DECISION DELEGATED TO DEVELOPMENT MANAGER

Application No: H12-0190-20 **Applicant:** Mr & Mrs S Laker
Proposal: Extension and Alterations
Location: Oakwood Marriots Gate Luton
Terminal Date: 27th July 2020

DRAWING TITLE
SUNLIGH AND DAYLIGHT PLANS

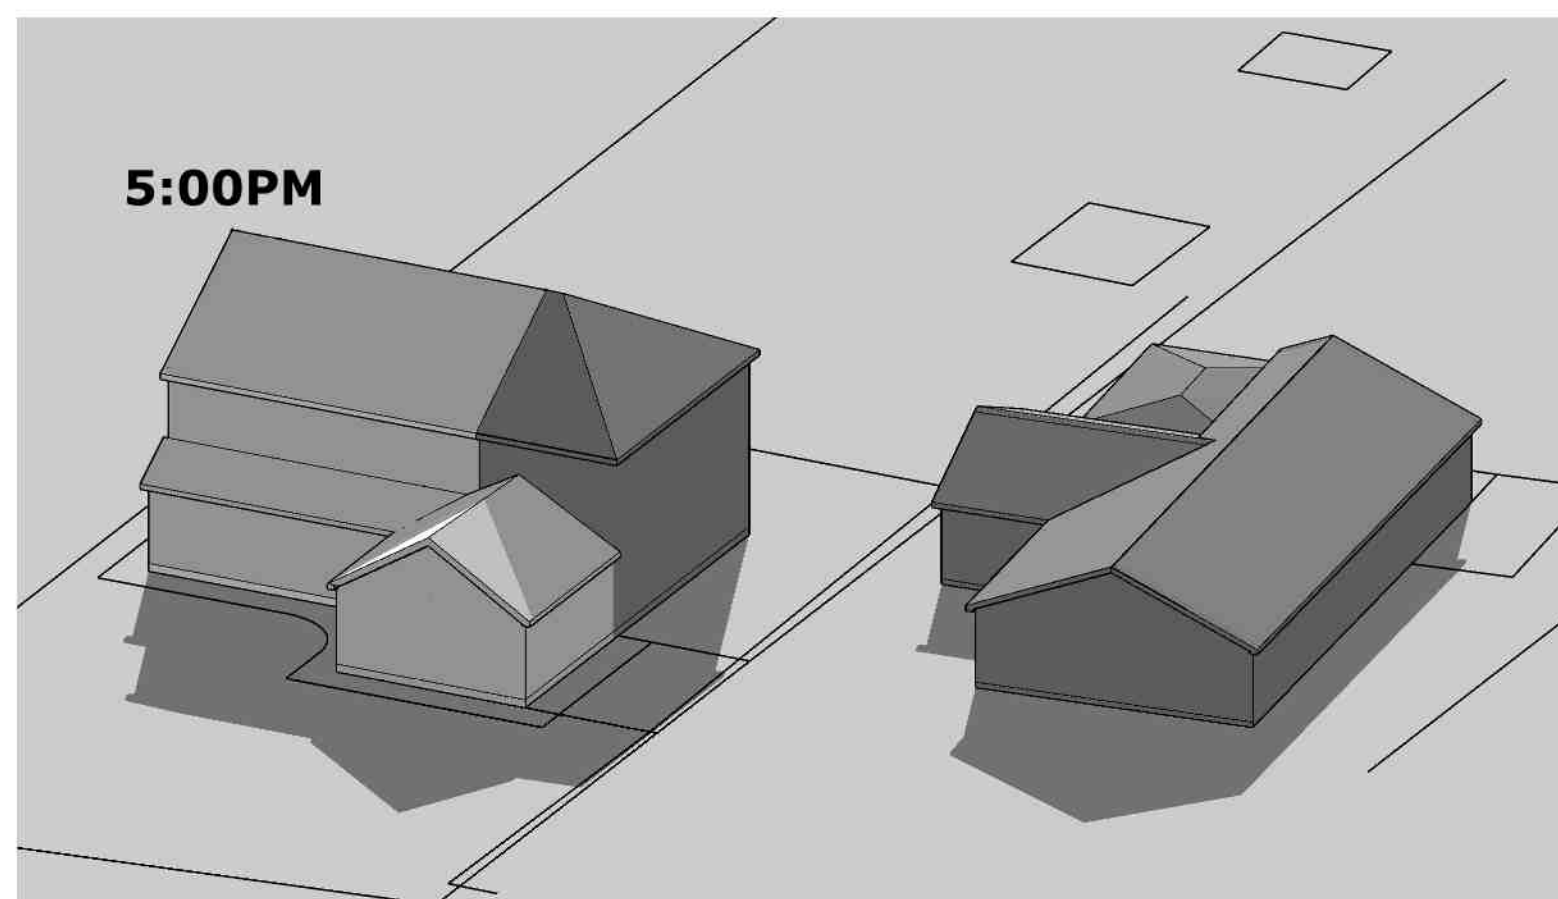
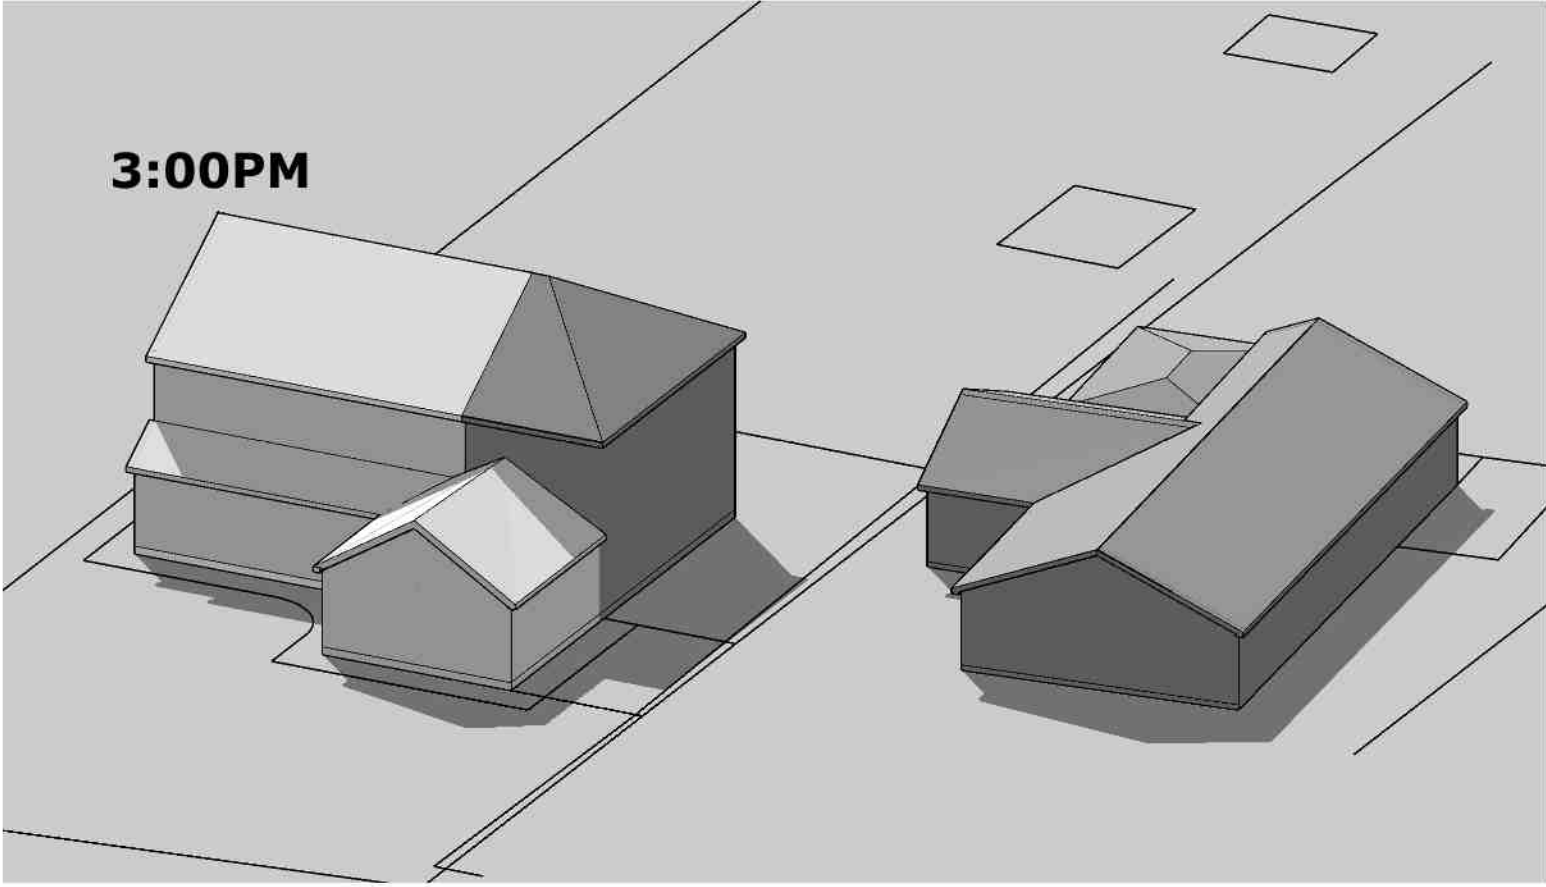
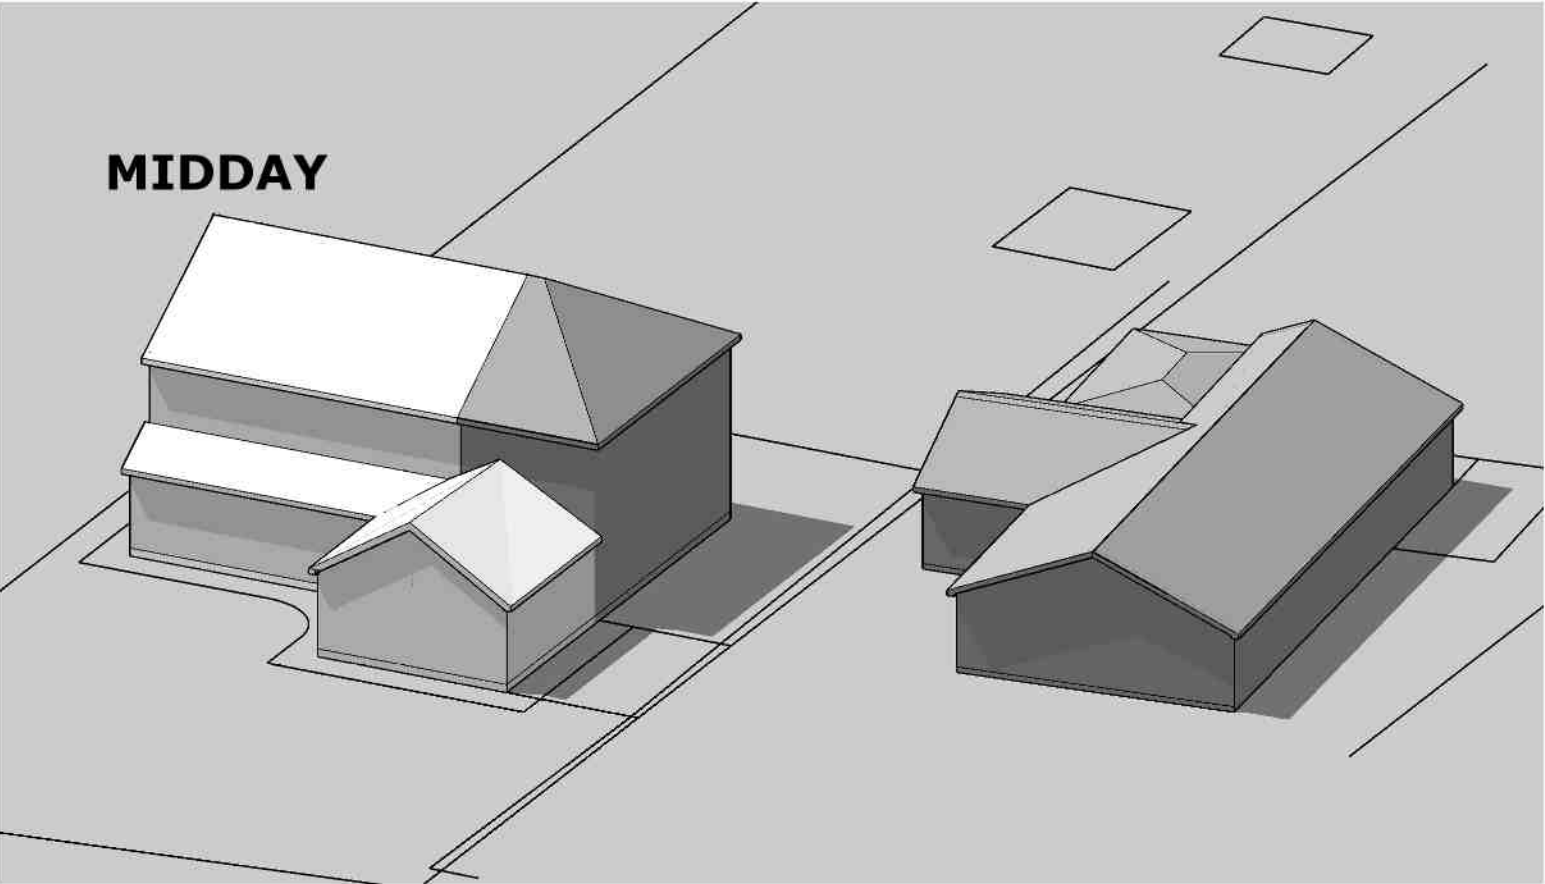
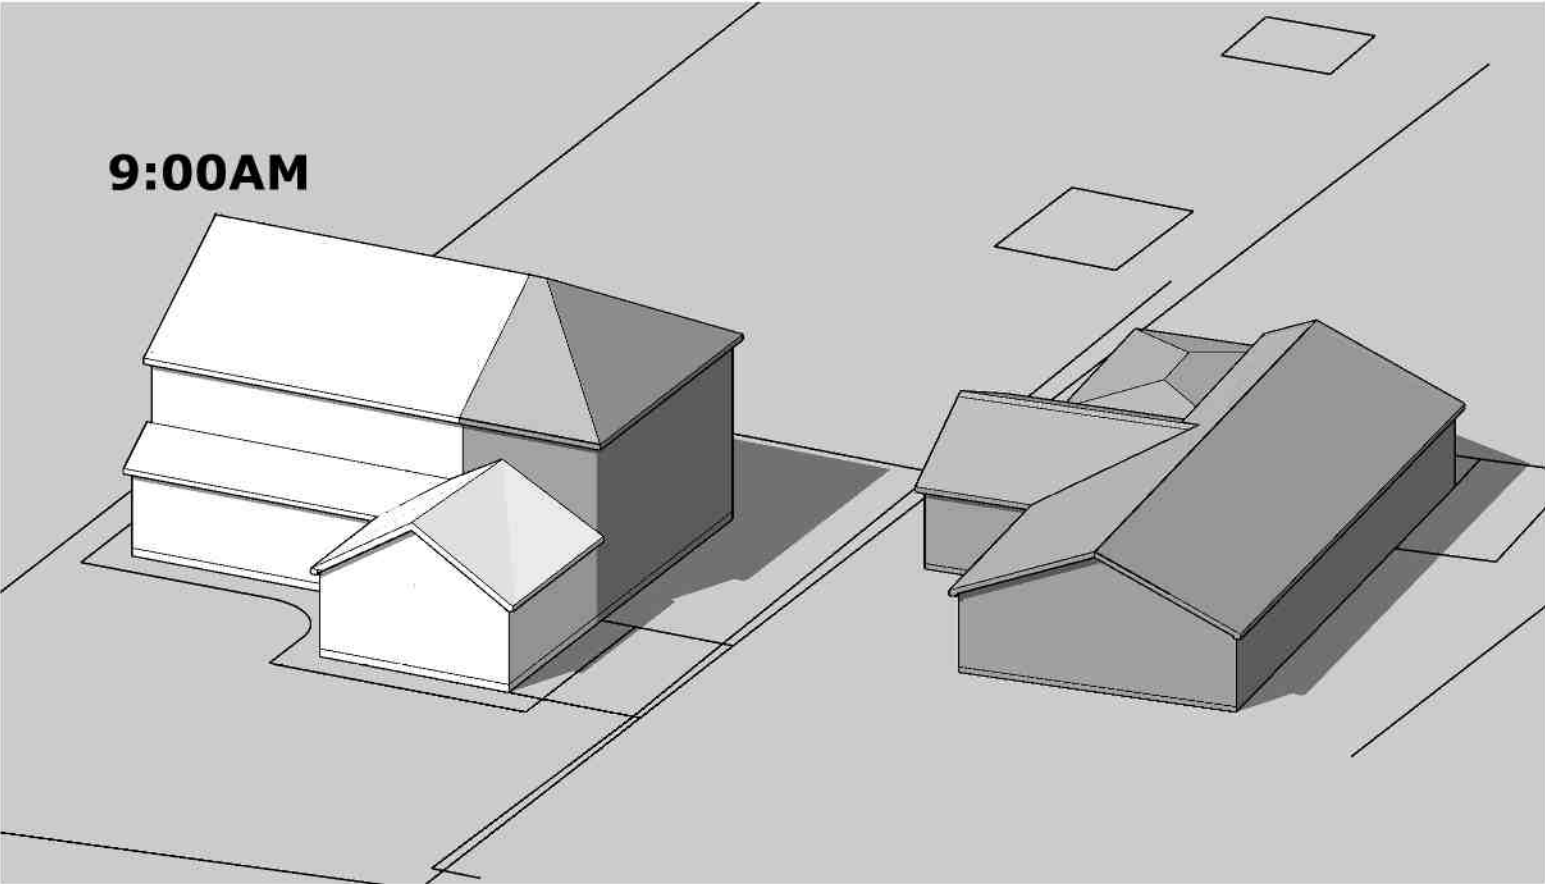
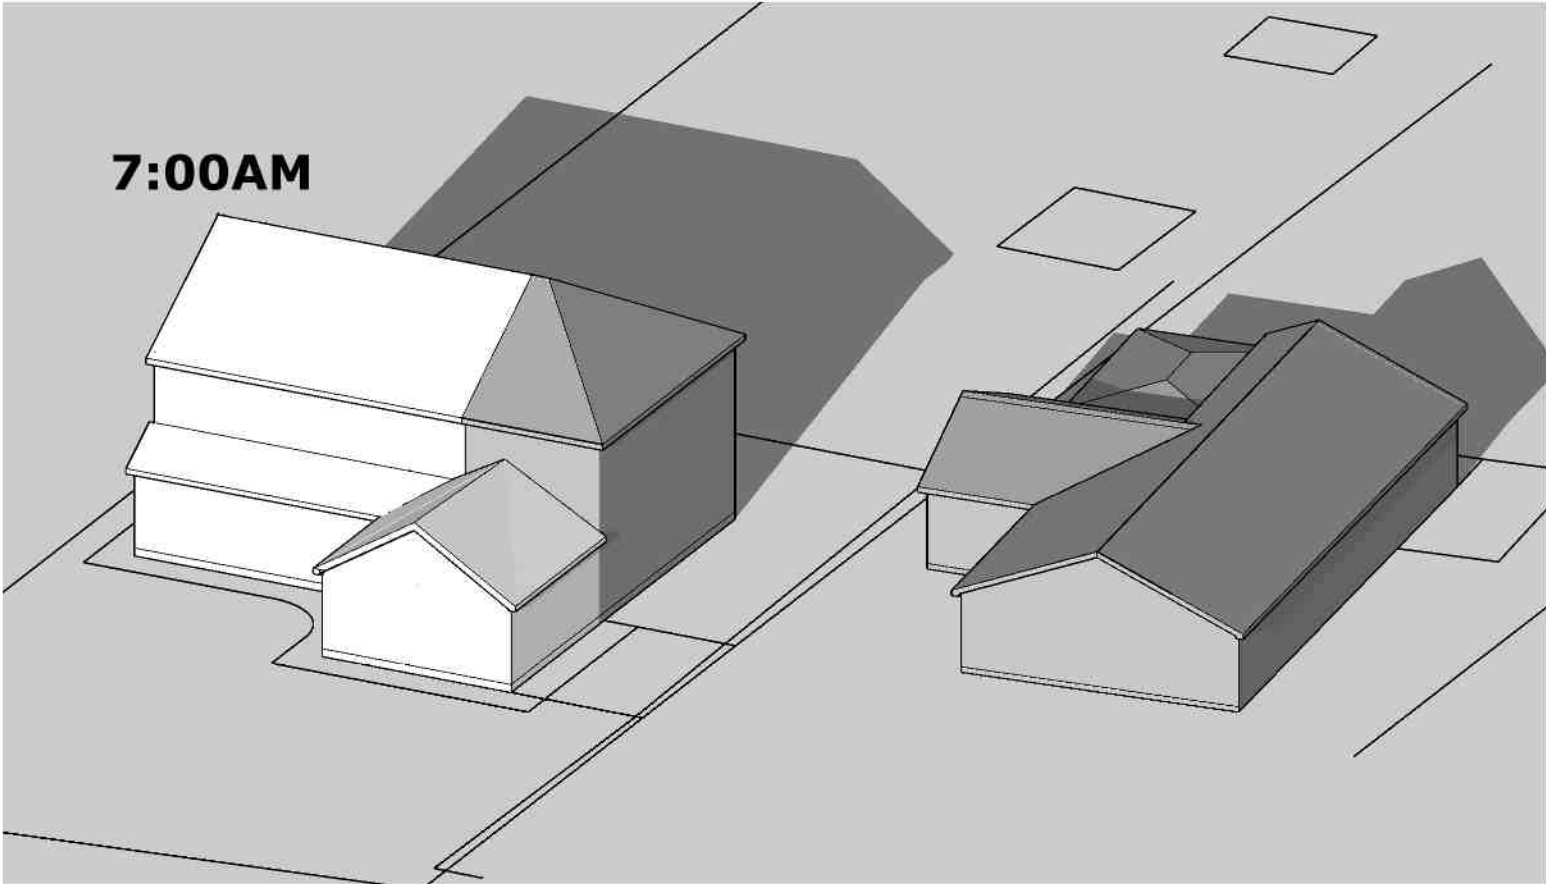
The BRE '25 degree rule' is a test to ascertain the likely effect a proposed development will have on an adjacent building with regards to obstructing daylight to existing windows/rooms. This test is applied on Dwg. No 3620-20-03 and the 25 degree angle appears to be complied with. Notwithstanding this, the applicant has submitted further plans which show the likely shadowing based on the height of the sun at 10am and 2pm on 21st December (winter solstice). This shows that the closest window to the proposed extension (lounge) is already overshadowed by the dwelling as existing at 10am on that date. At 2pm, the proposed extension would only very marginally interfere with the side facing dining room window, by a matter of a few centimetres. In light of this, it is not considered that the likely impact in terms of daylight levels and warmth is so significant as to warrant refusal of the application.
